Land at Bilsham Road, Yapton
Planning Reference: Y/70/22/DOC

Approval of details reserved by condition imposed under ref Y/91/17/OUT relating to Condition Nos 9 - surface water drainage

At this stage we would not recommend that the condition is discharged until further information as outline below is resolved and provided:

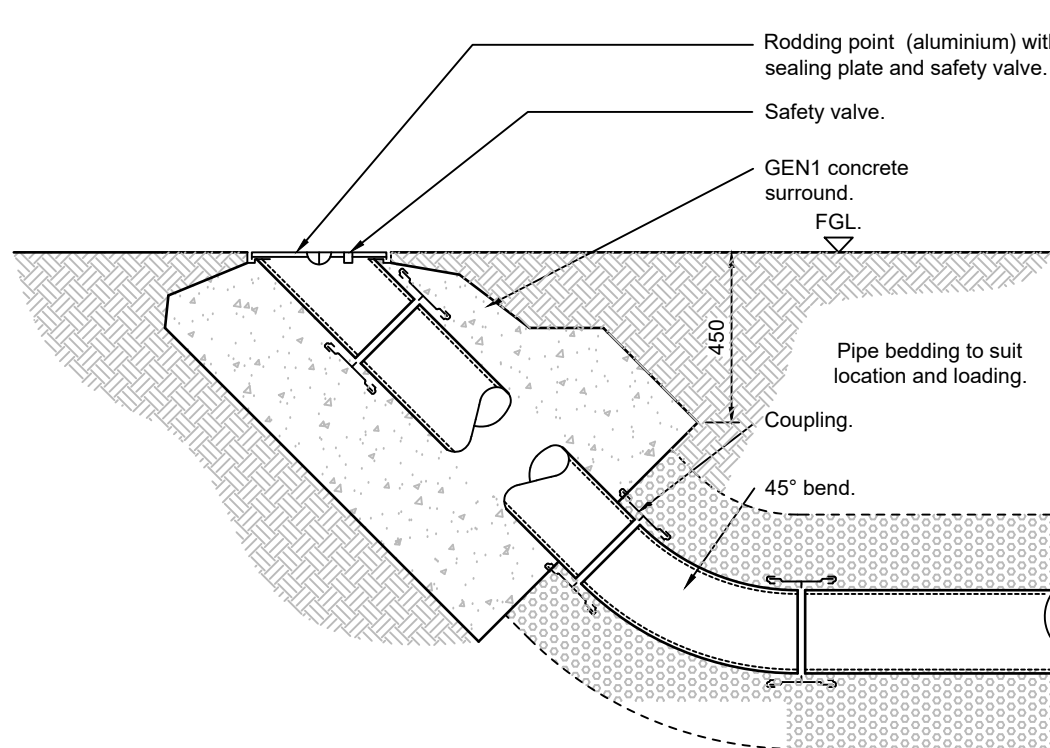
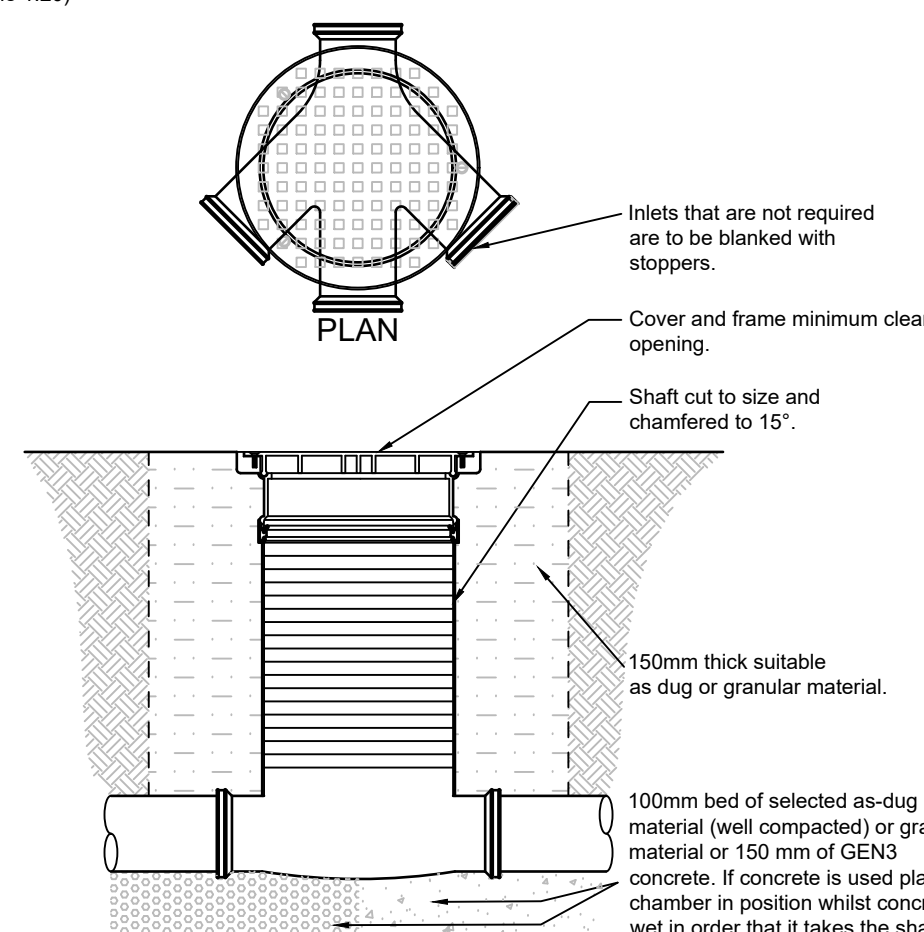
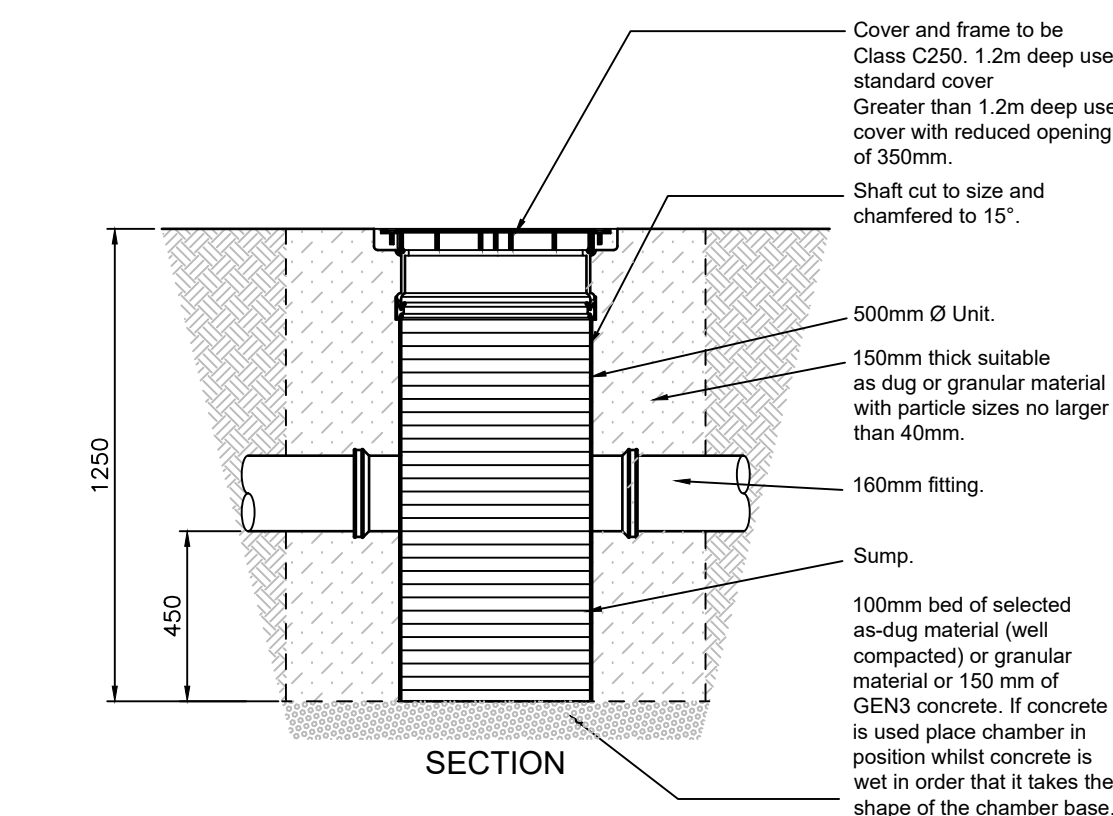
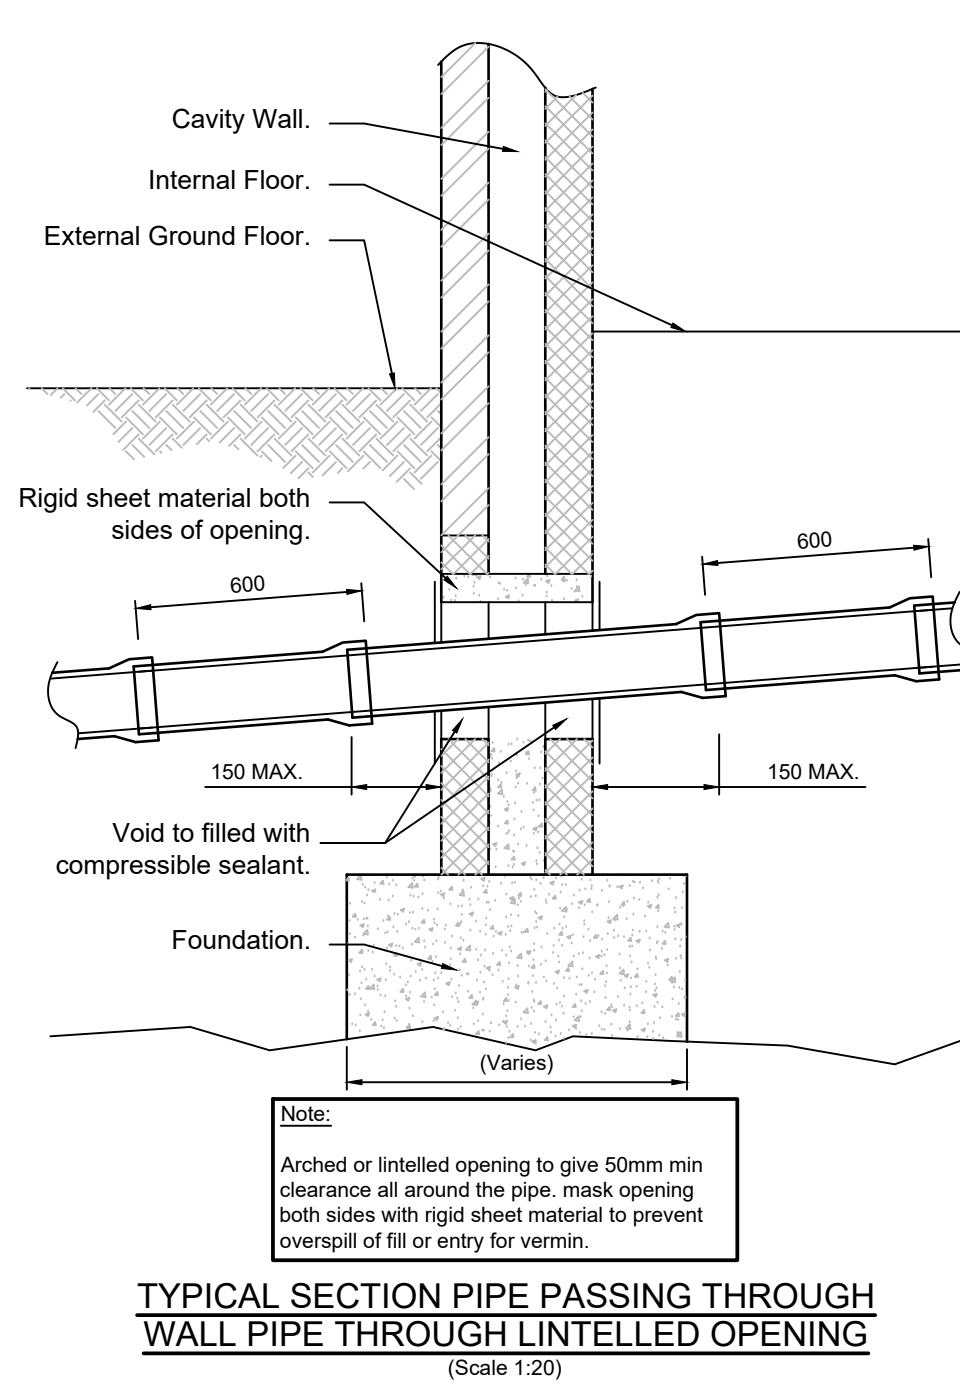
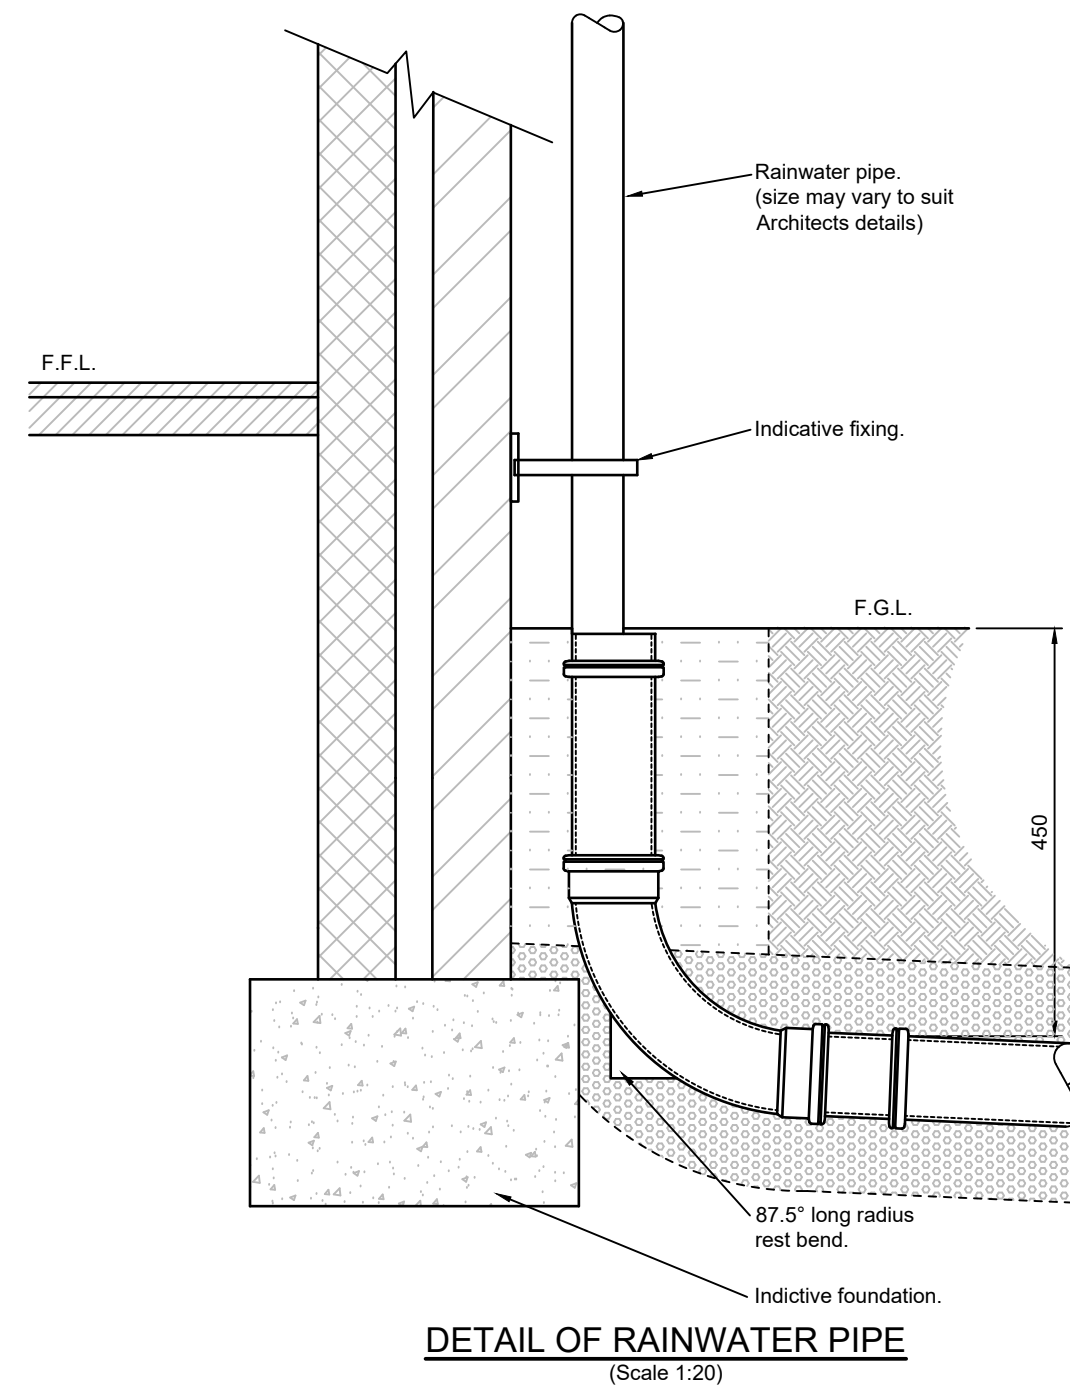
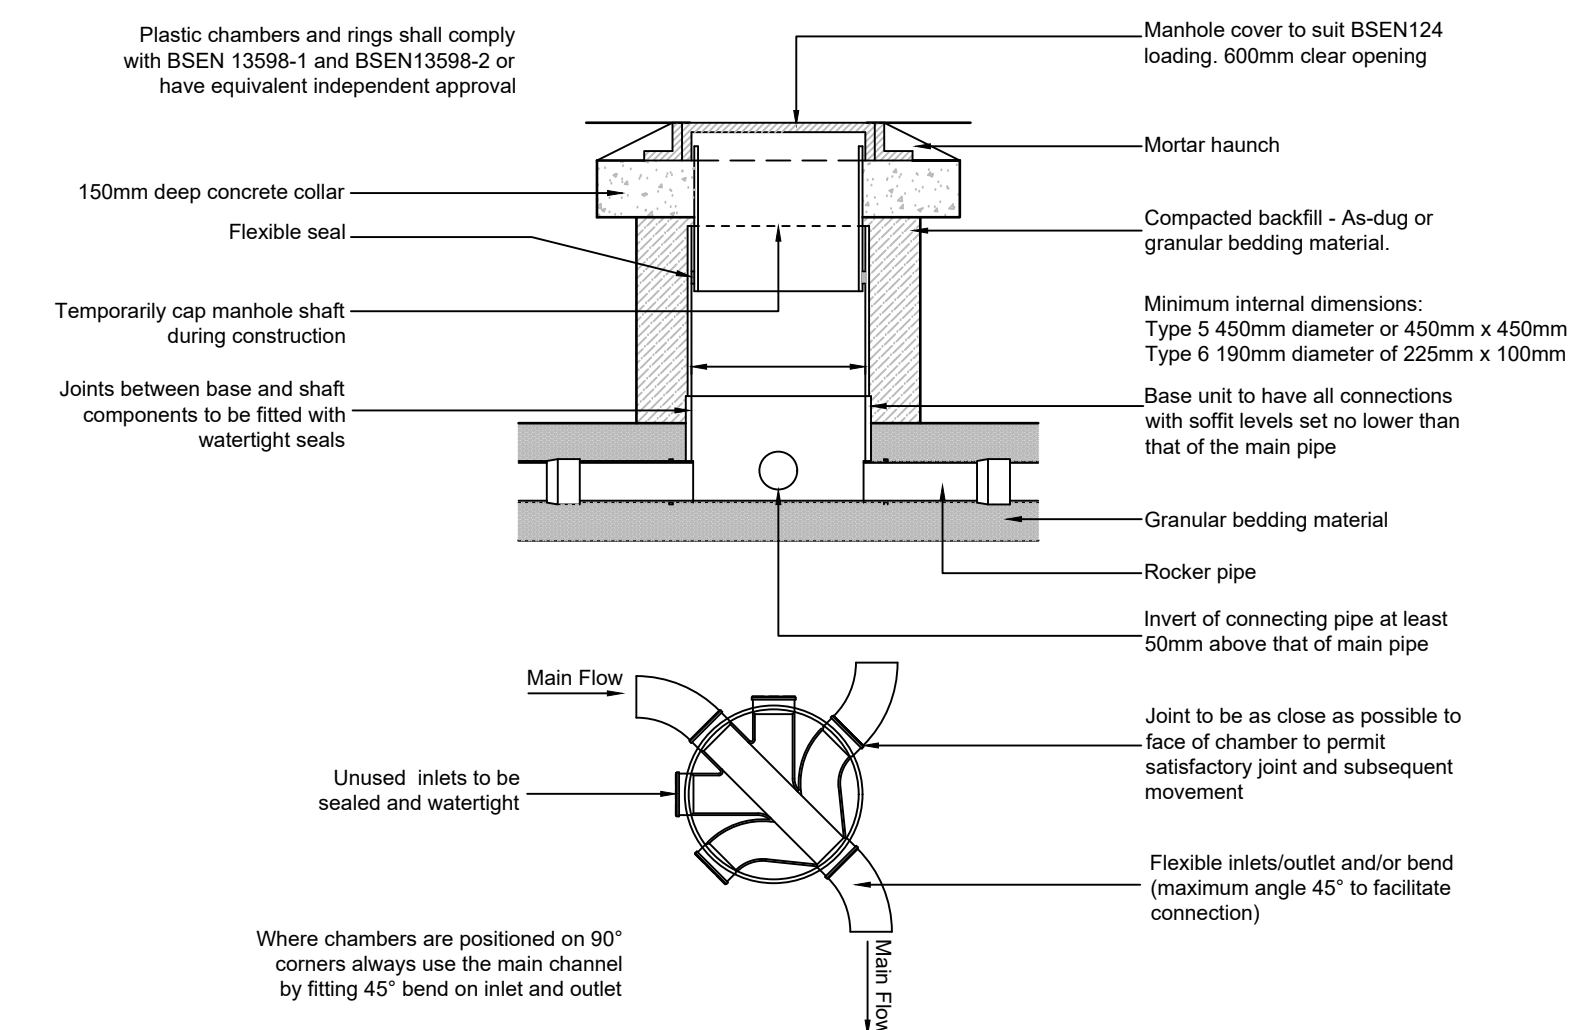
16. *Please provide a construction detail of permeable paving which clearly defines the construction, i.e. blocks, bedding, membranes, sub-base, tanking membrane. Materials and depths should be clearly defined.* The construction detail shown on drawing D1956-15.2 conflicts with that shown on D1956-15-3A. These need to be updated to ensure there is no conflicting information. In addition to this its not clear why part infiltration has not been sought in areas where the infiltration has demonstrated that this is achievable. The applicant should clarify clear reasons as to why infiltration techniques have not been used for the permeable paving in the areas within the vicinity of the following test locations: TP05; TP04; TP01.
